planning re moor lane

28 Oct

[2025/92713](#)

PLOTS 3, 7, 8 & 9

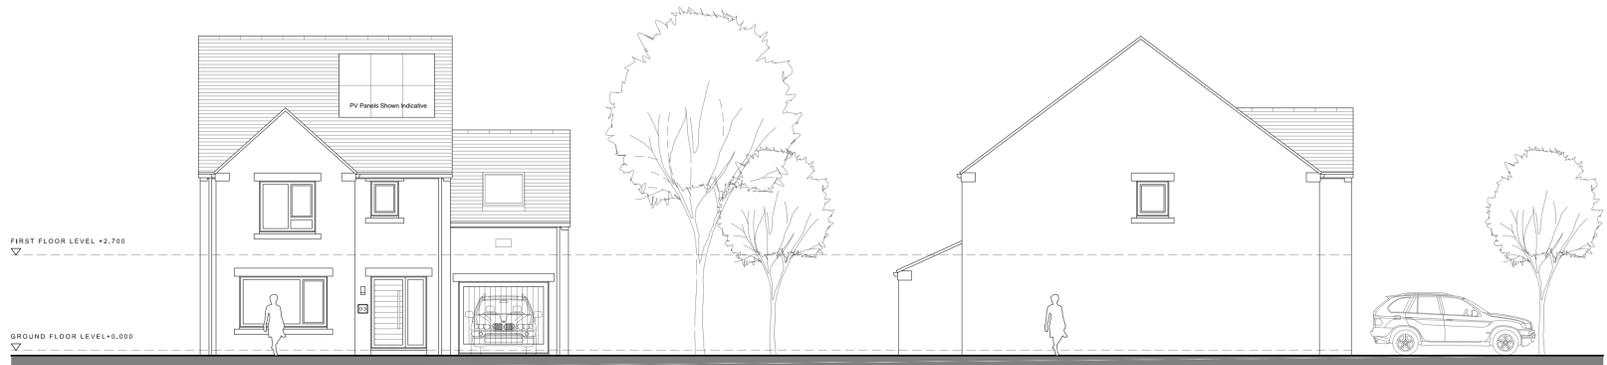
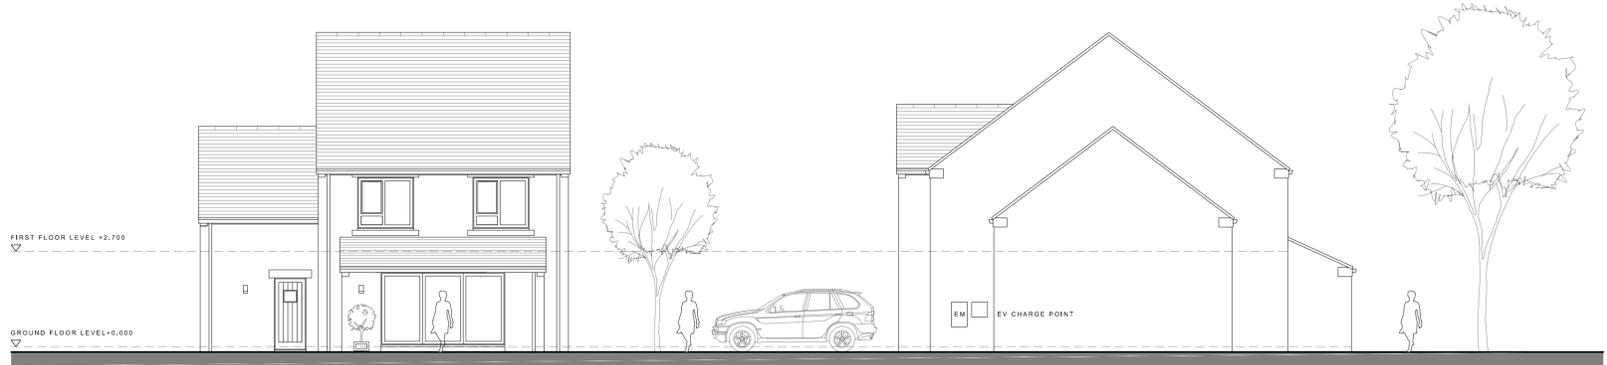
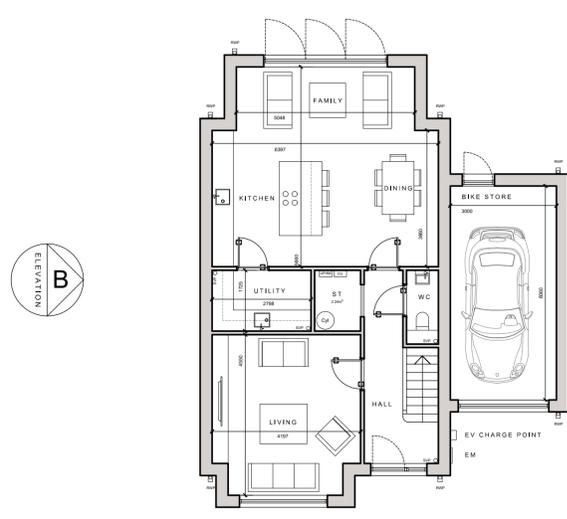
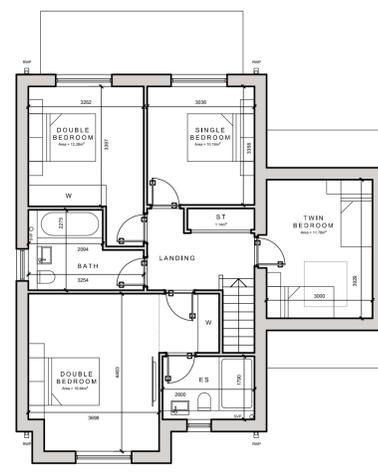
Plots 5 to 10 will need specialist contractors to install raft foundations.

Plots 9 and 10 also require a high pressure grouting technique to stabilise the land. A permit is needed as the treatment will disturb Mining Remediation Authority interests.

Plots 7,8,9 and 10 have to take their bins to a collection point presumably because the bin lorry can't access these properties. Quite a distance for plot 10 - does this comply with building regs?
